Application No: LU/55/22/L
Site Address: The Flintstone Centre East Street Littlehampton BN17 6AW
Description of works: Listed building consent for the installation of 3000mm high welded mesh fencing and associated single leaf gate along a section of the northern boundary line and along the rear elevation, Ornamental fencing and associated gates to be installed, located adjacent to the existing southern side entrance to the building, as well as the installation of 3000mm high welded mesh fence encapsulating the existing boiler room to the rear of the building, demolition of existing side secondary entrance including existing ramped access and associated fittings. Repairs to the section of wall affected by the removal of the entrance.

Thank you for your internet representation made on 8th March 2022 which has been recorded as an objection with the comments as follows:

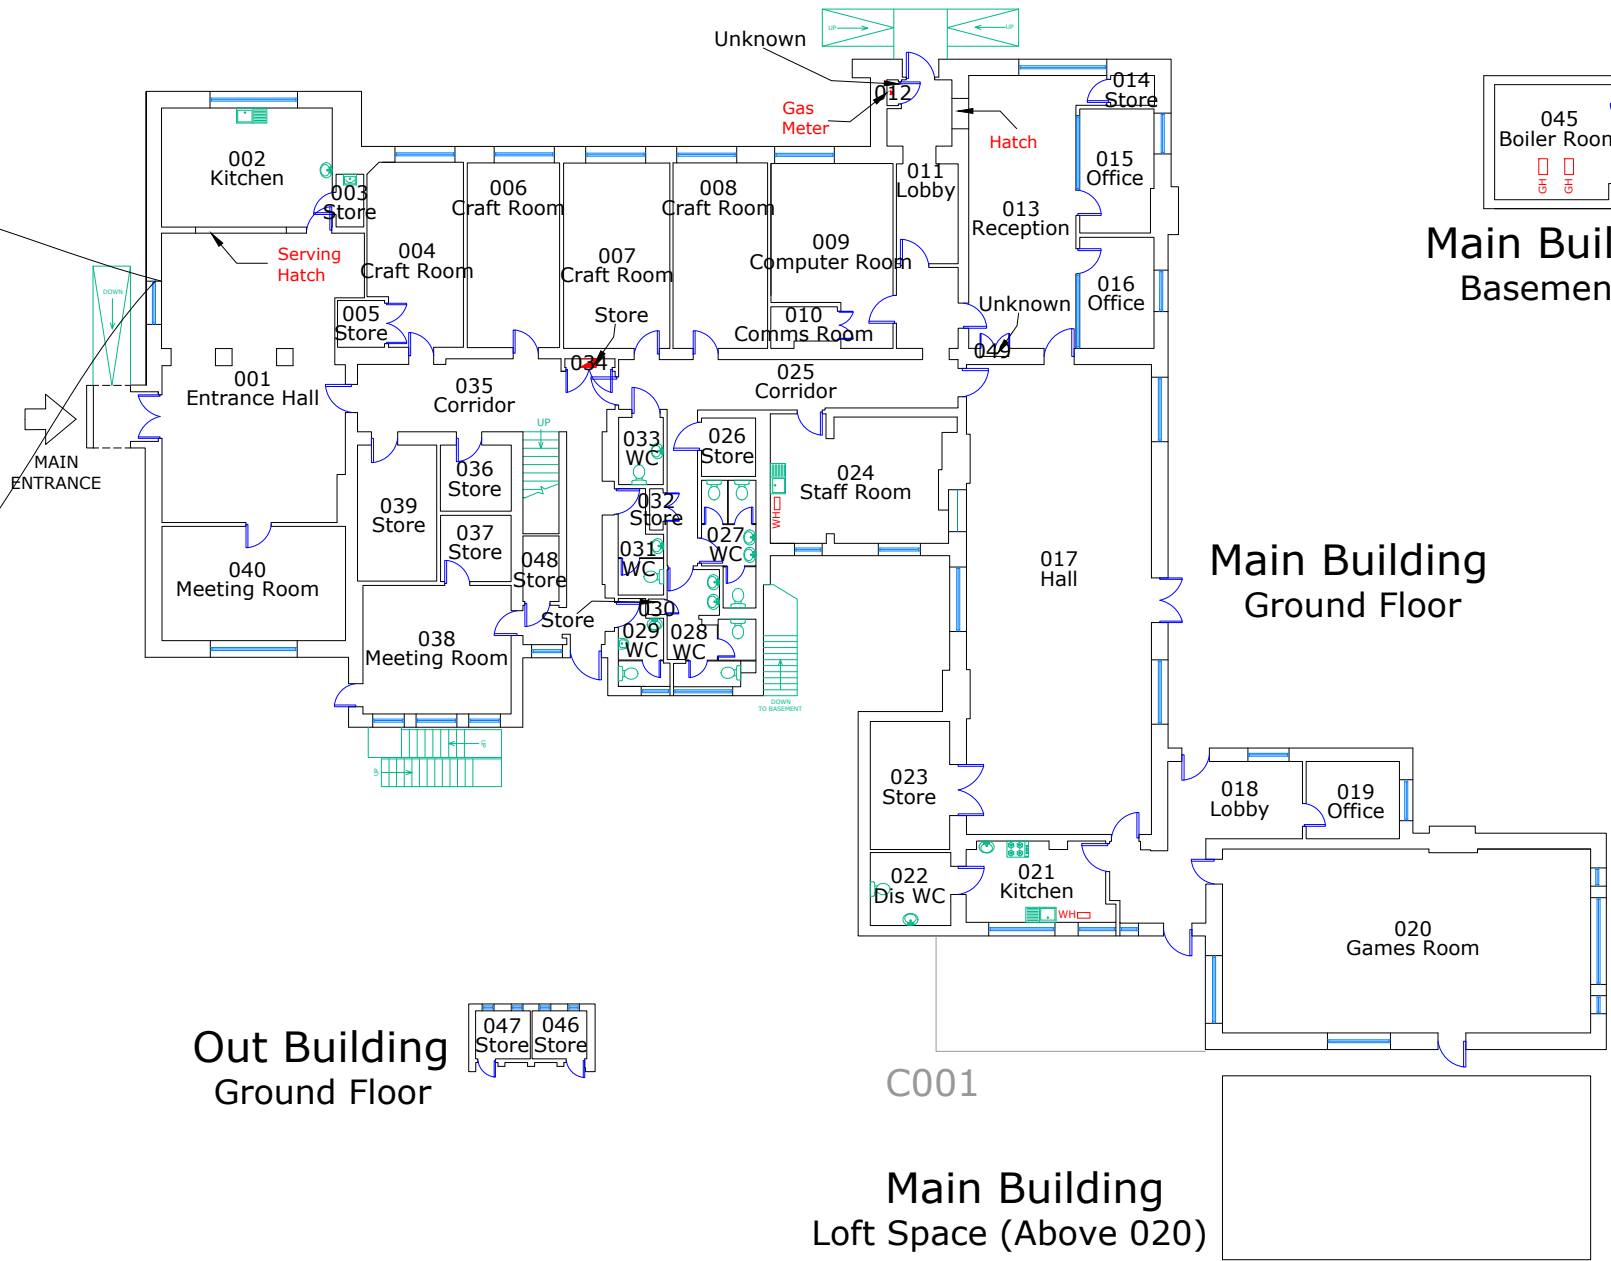
The Location Plan and Proposed Fencing Layout plans do not show our four year old development to the rear (The Old Dairy Farm) giving a very misleading view of the impact of the mesh weld fence to the rear.

Title:
THE FLINTSTONE CENTRE
FENCING LAYOUT AS PROPOSED

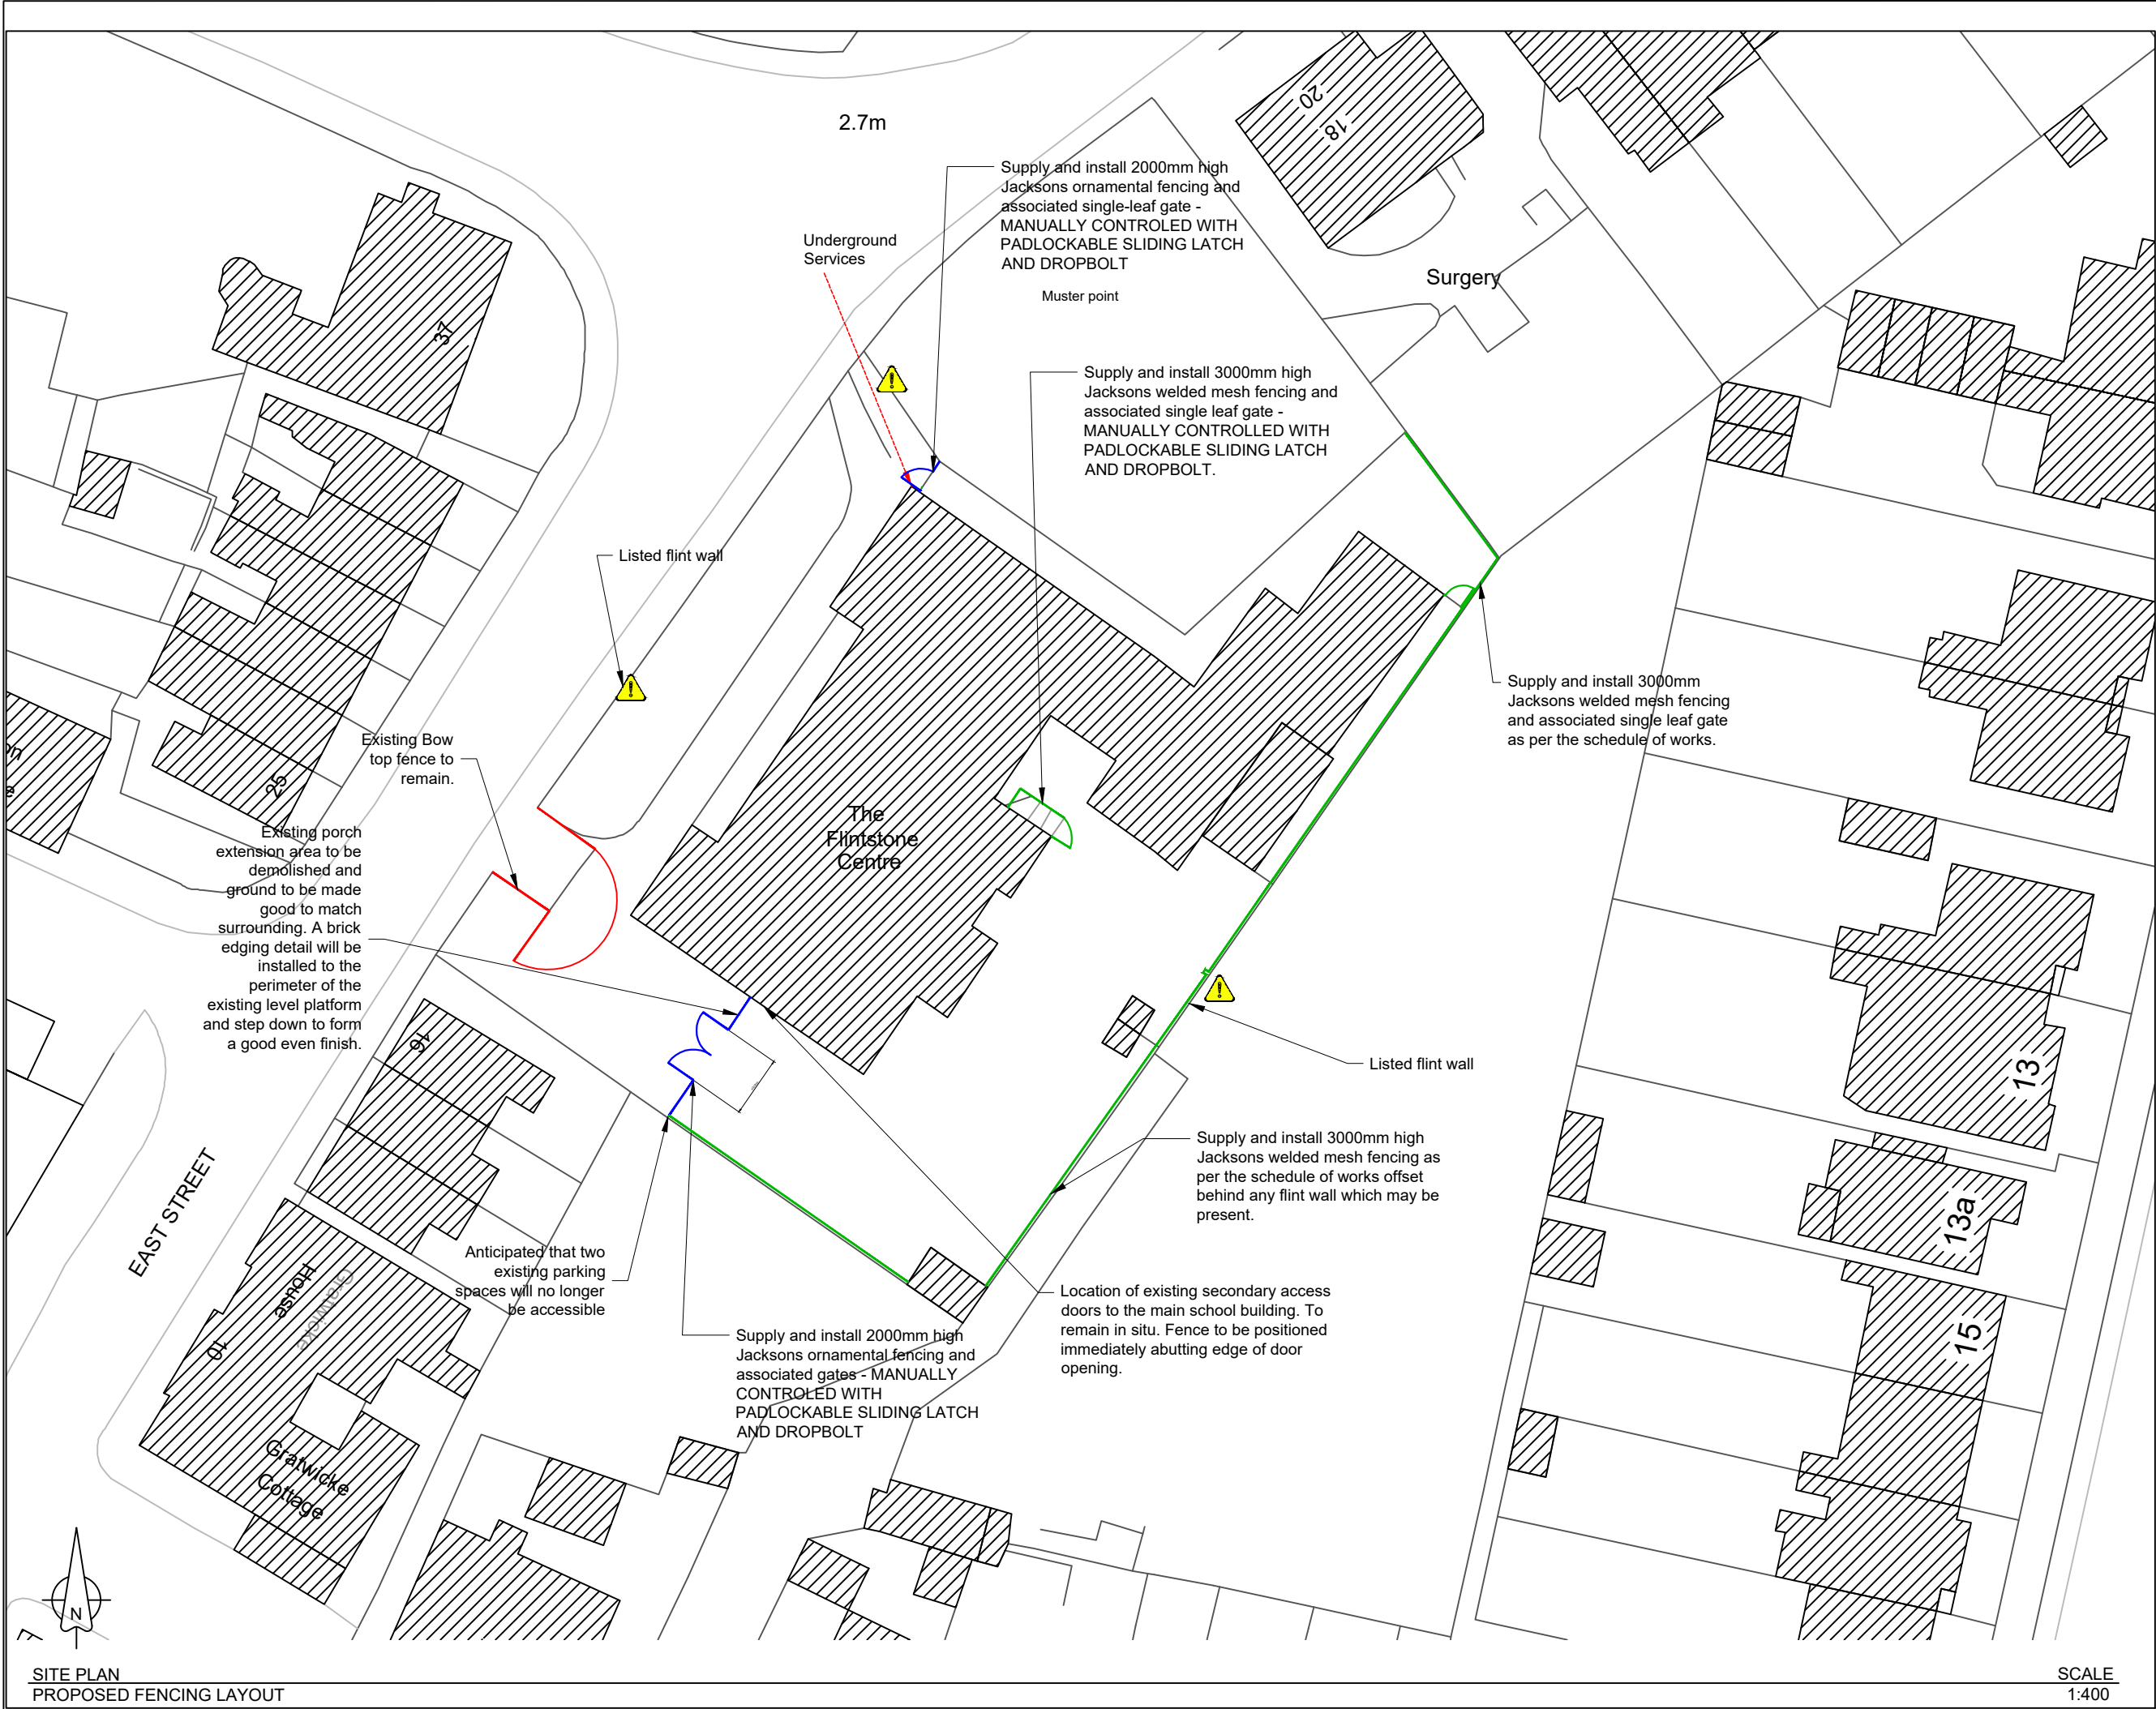
The Heritage Impact Statement says that the rear flint wall is not listed, yet the Proposed Fencing Layout plan says it is listed. Which is correct?

Does the proposed fencing design allow for maintenance of the flint wall?

The proposed Euroguard weld mesh fence is not in any way in keeping with the conservation area and would be erected within 5m of the heritage design and materials used for the gate and fence to the Old Dairy Farm.

This weld mesh fencing would be visually incongruous to the residents of The Old Dairy Farm. It would be erected within 10m of the front facade of numbers 1-5 The Old Dairy Farm, protruding above the existing flint wall, and also along the garden wall of number 8. The Euroguard weld mesh fencing looks more appropriate for use surrounding a prison or similar. Previous discussions with the Council stressed that the planning submission would include heritage/conservation style fencing to the rear, and not an ugly and inappropriate weld mesh fence.

Drawn S.leeper		TITLE SALES DRAWING 2m HIGH EUROGUARD REGULAR FENCE	
Date 15/06/2006			
Checked Chris J		CUSTOMER ACK No.	Drawing No. J6/01058 Sheet 3
Size A3	Scale 1:20 U.O.S

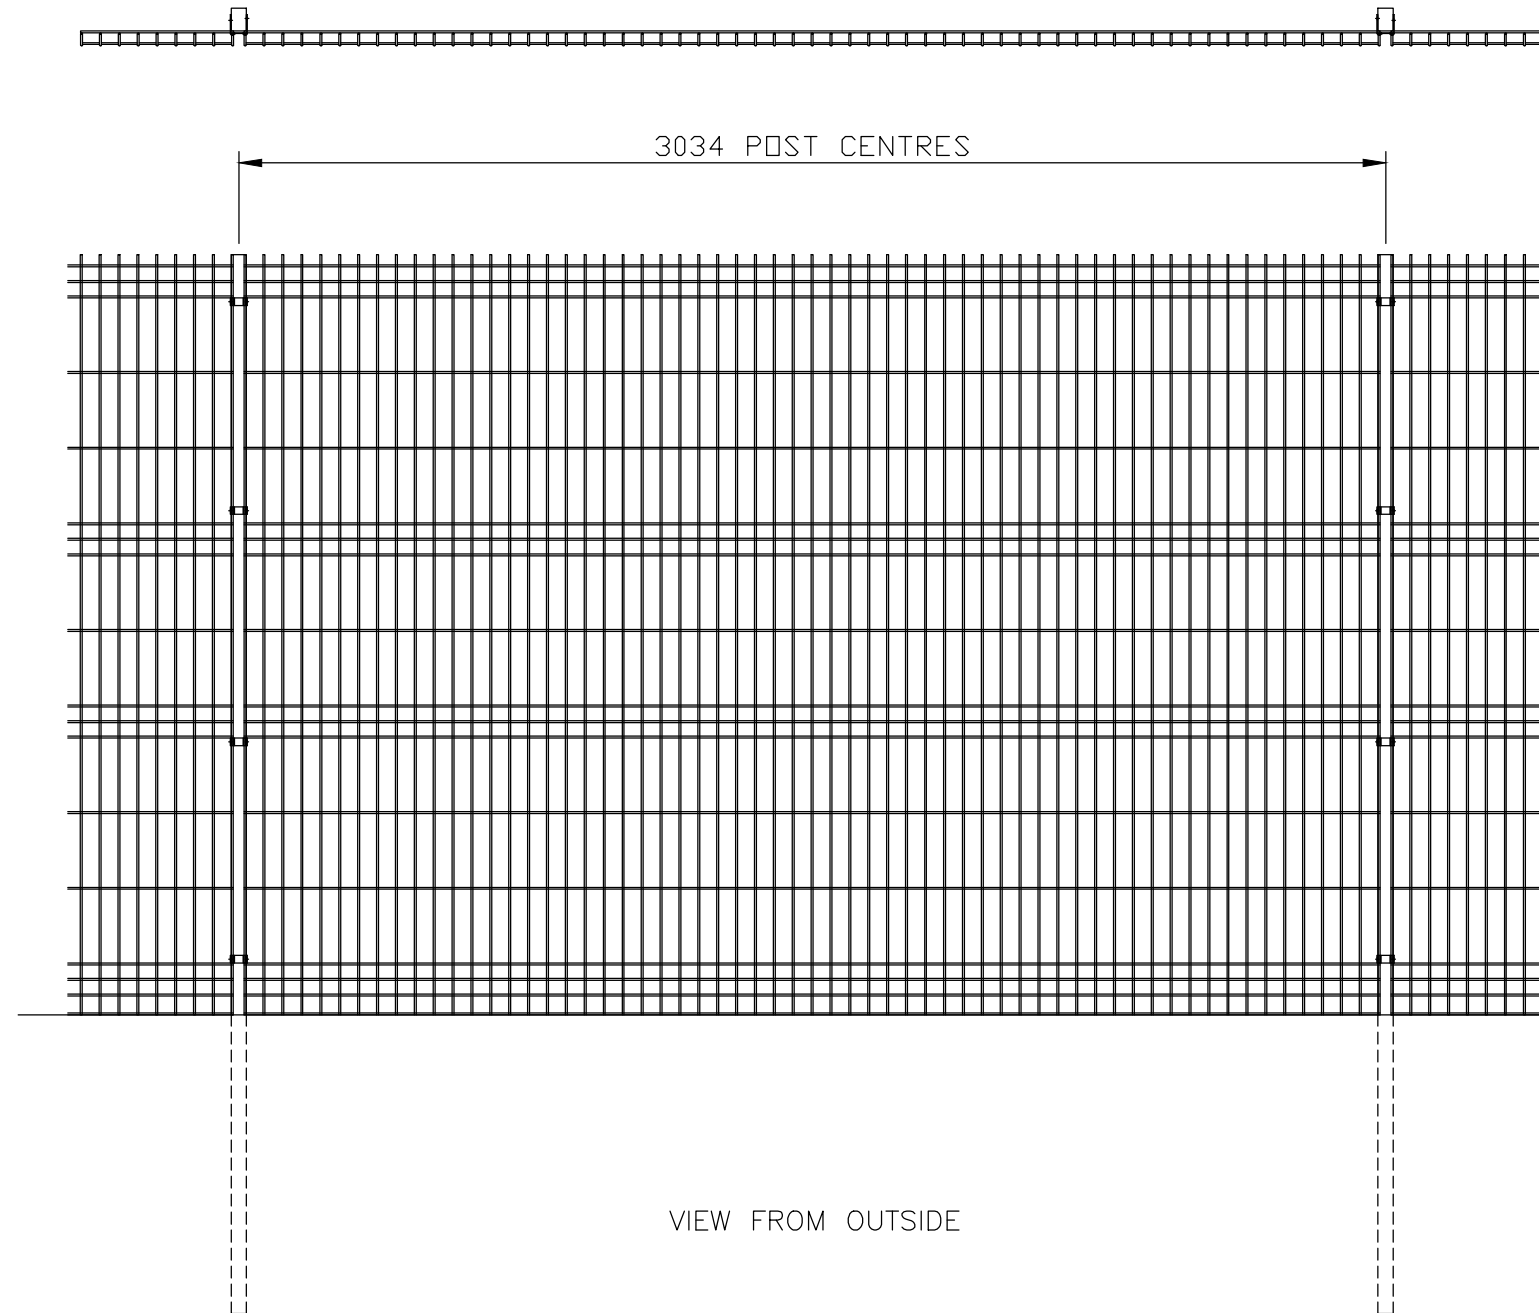
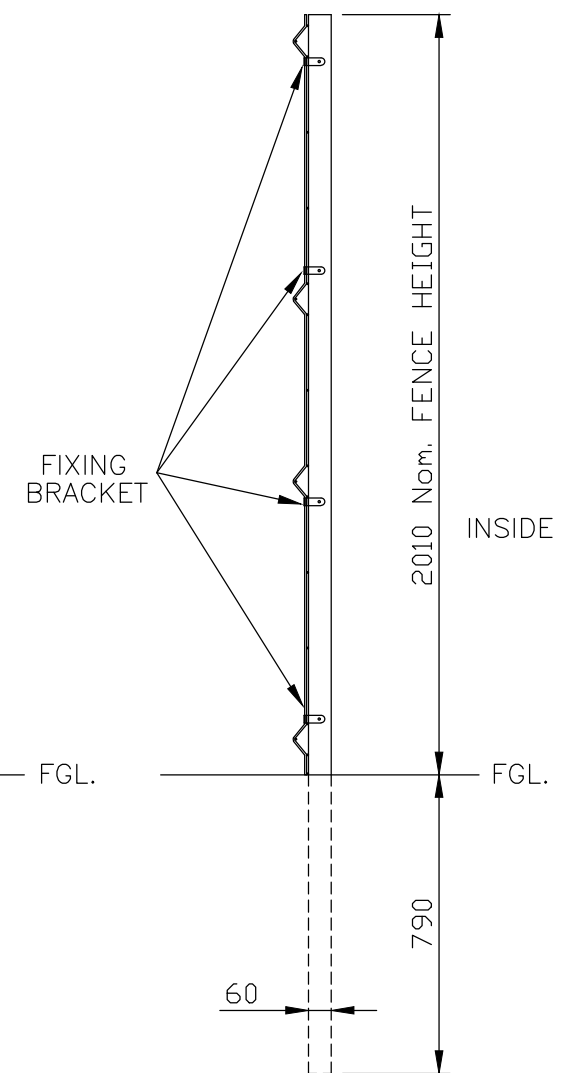
The proposed fence is welcomed as a measure to stop pupils from the school climbing over the wall to and from our development, The Old Dairy Farm, which sits behind the Flintstone Centre. However, the proposed Euroguard weld mesh fence is ugly and inappropriate, especially considering that this is a conservation area and that tight planning restrictions requiring an ornamental/heritage style gate and fencing were applied to the Old Dairy Farm development just to the rear.
